June 10, 2015

**RE: Warehouse, 4455 Anaheim  
Grading and Drainage Plan  
Engineer's Stamp Date 5-13-2015 (File: C17-D123)**

Based upon the information provided in your submittal received 5-14-15, the above referenced plan cannot be approved for Building Permit until the following comments are addressed:

ENGINEER'S SEAL	4455 ANAHEIM NE	DRAWN BY WCWJ
	GRADING AND DRAINAGE PLAN Rio Grande Engineering 1606 CENTRAL AVENUE SE SUITE 201 ALBUQUERQUE, NM 87106 (505) 872-0999	DATE 5-13-15
		SHEET # —
		JOB # 21515

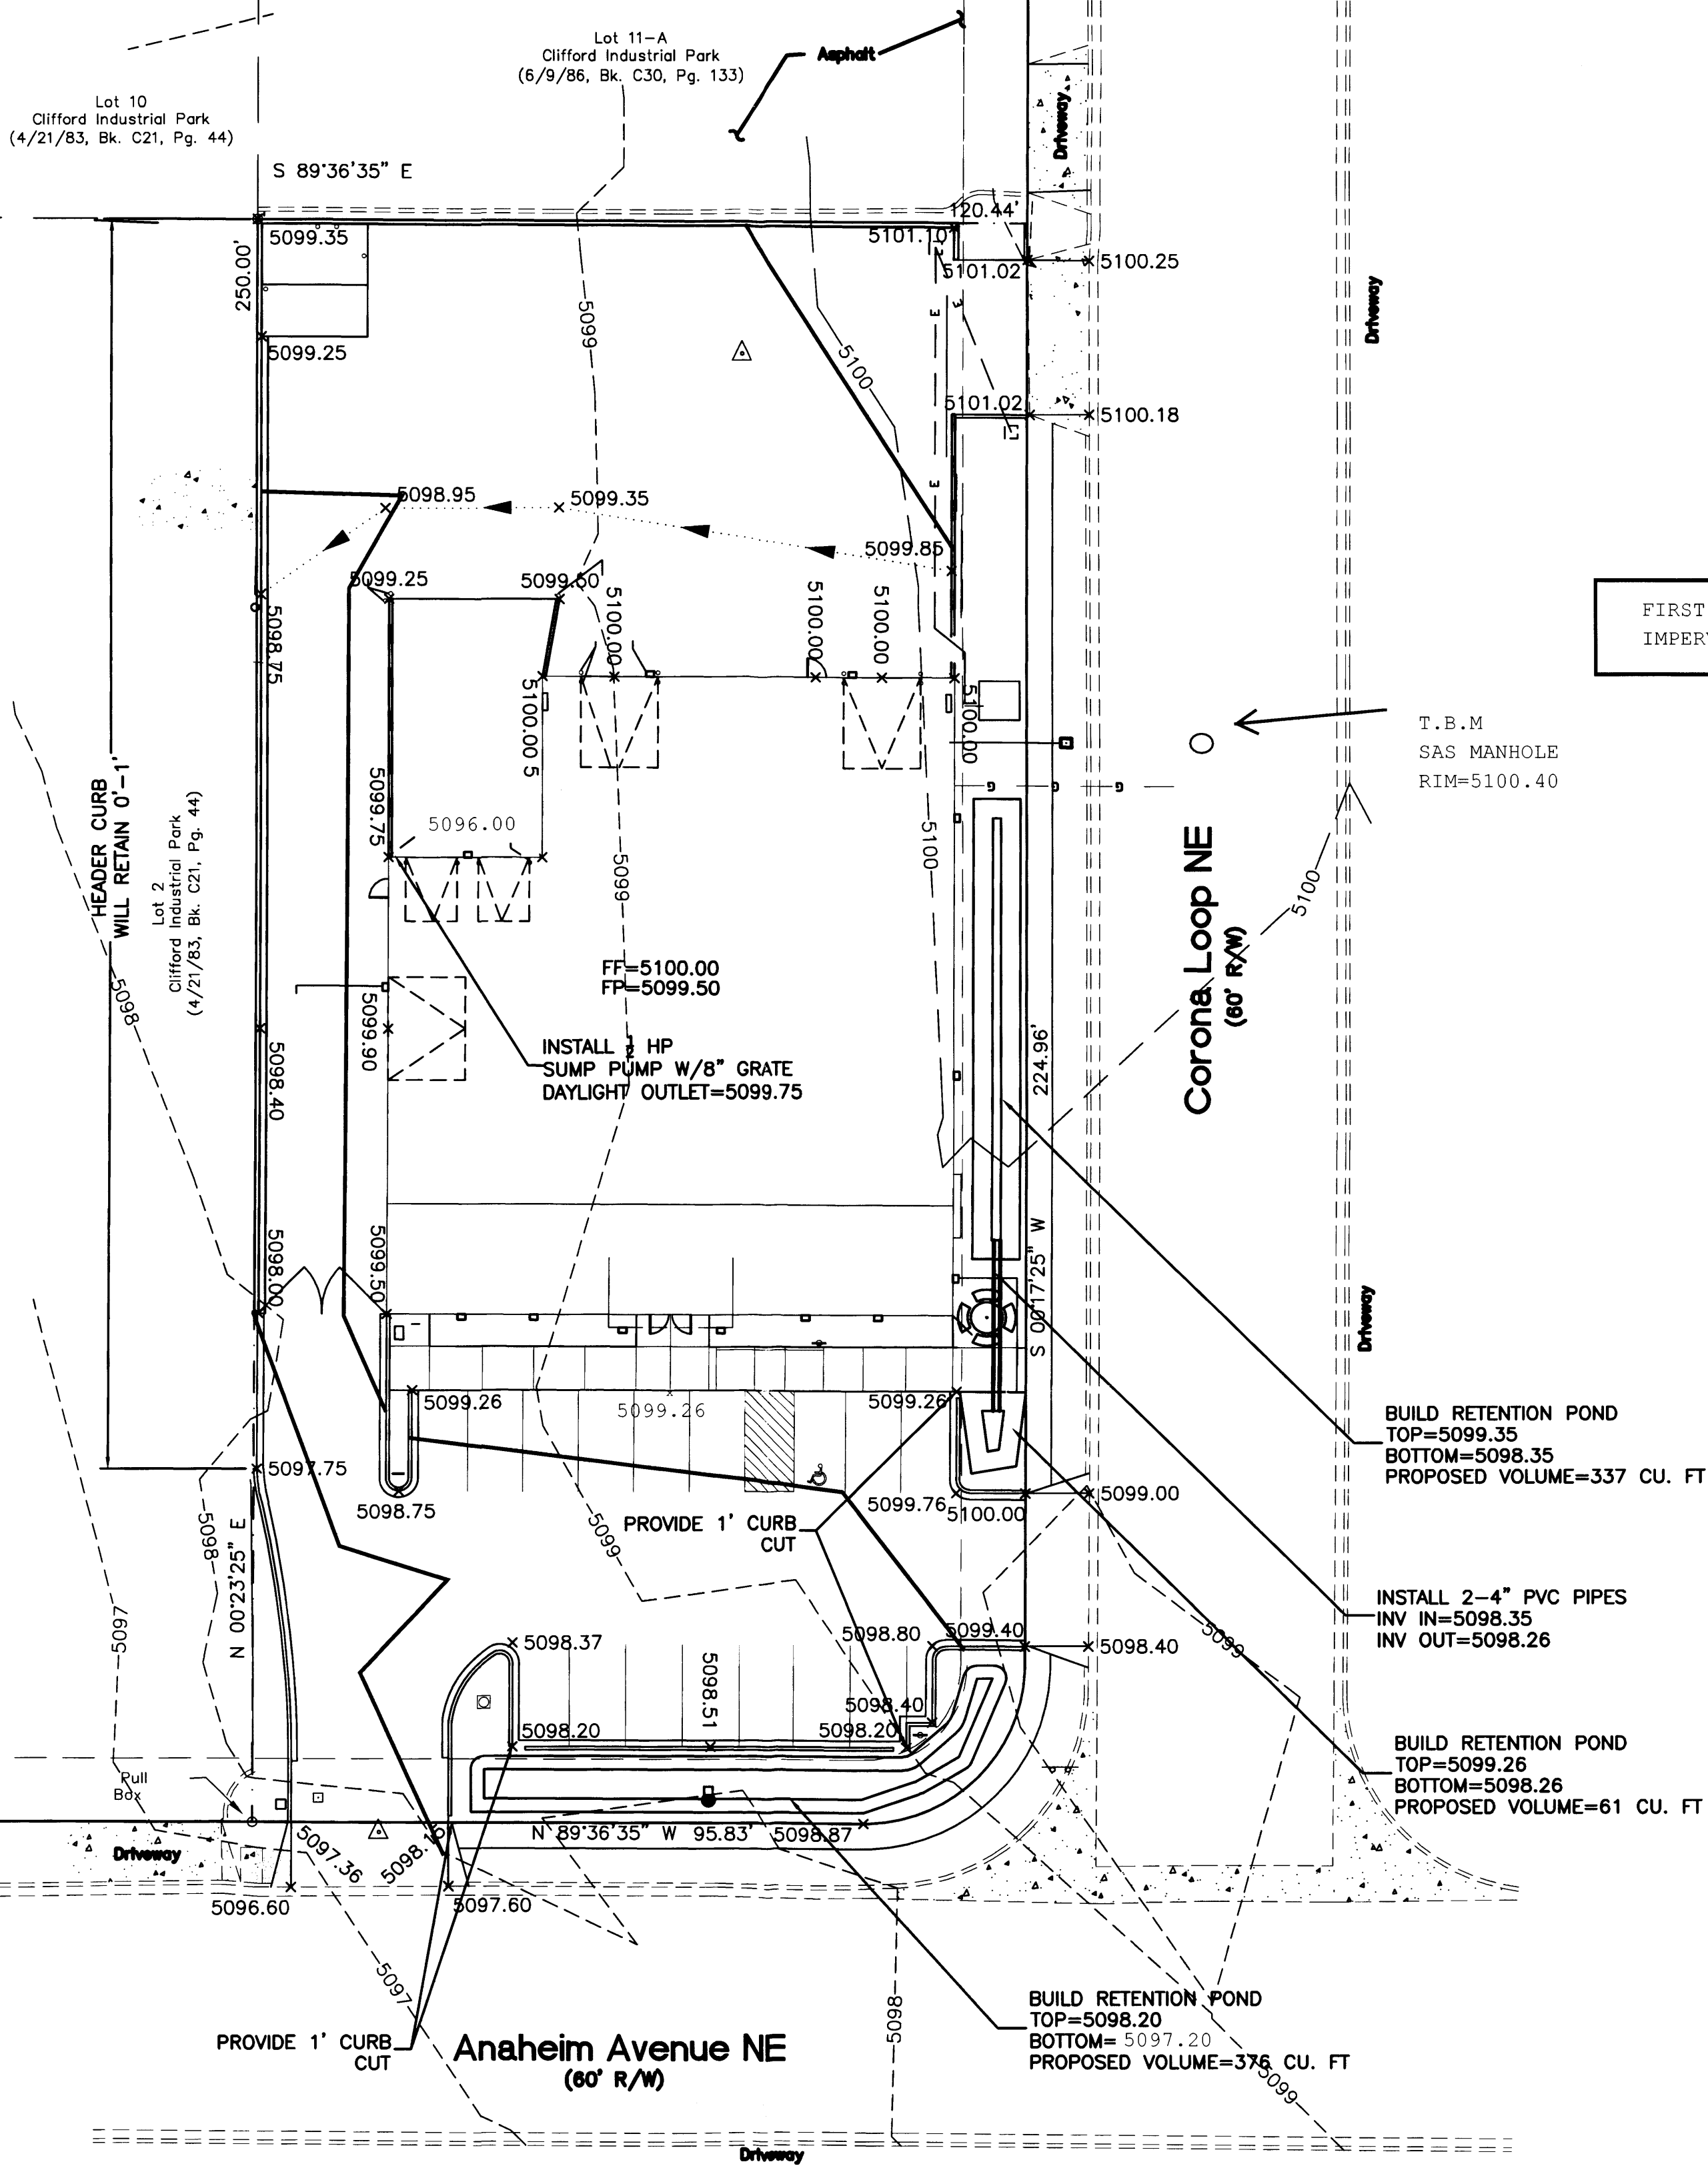
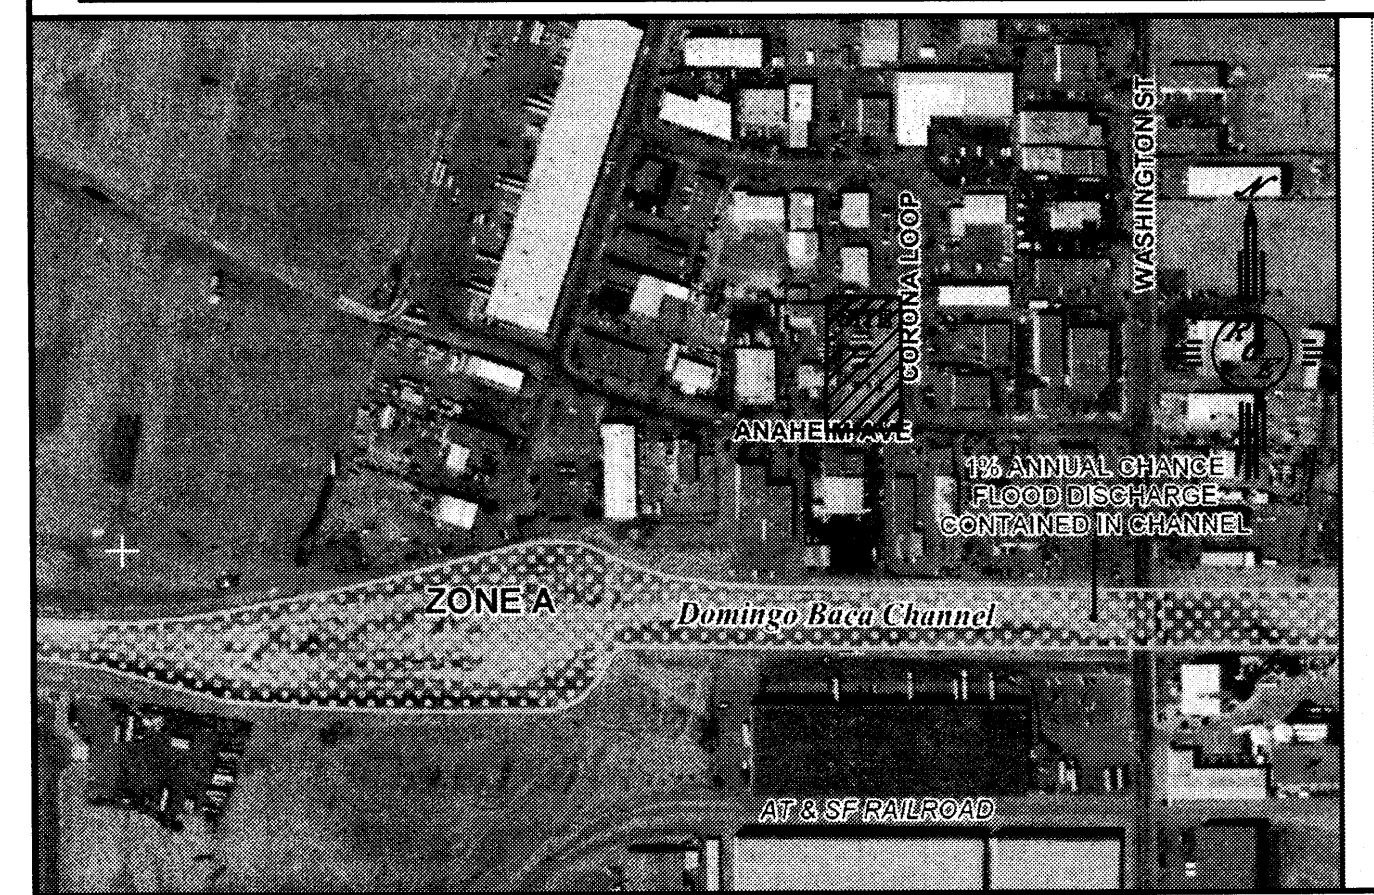
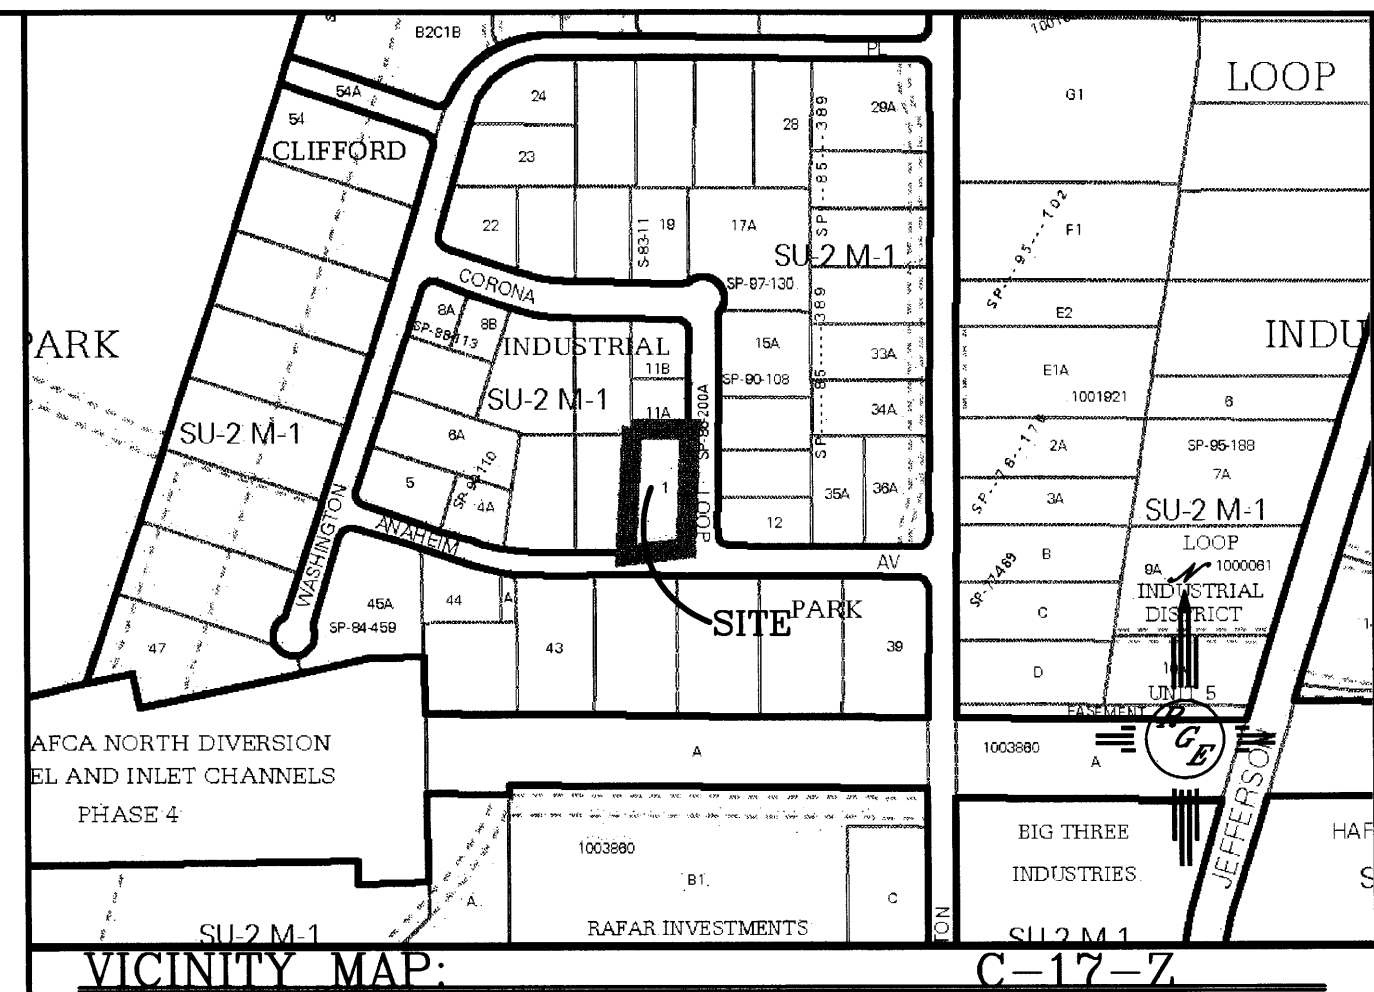
- 1) Provide new and existing curb linetypes and building boundary within legend. Label any gravel areas as "gravel" and paved areas as "paved", and count gravel lot areas as land treatment type "C". Label any new curb and curb height on the plan view as applicable.
- 2) Show roof drain locations.
- 3) Show existing spot elevations for curb on Corona Loop and on Anaheim Avenue. Label proposed contours, and additionally provide boundary lines around each of the pond areas that define the top and bottom elevations of the pond. For the three retention ponds, indicate that they are for the "first flush" if this is the case. If new spot elevations provided are at flowline of curb, provide general note stating this.
- 4) Correct minor discrepancy in the drainage report which shows a discharge of 2.93 cfs under "Proposed Conditions" discussion and 2.36 cfs under "Summary and Recommendations".

- 5) For existing conditions analysis, it is recommended to analyze the parking lot as "C" land treatment as a compacted lot. This results in less of a difference shown for proposed discharge of the site versus existing discharge.
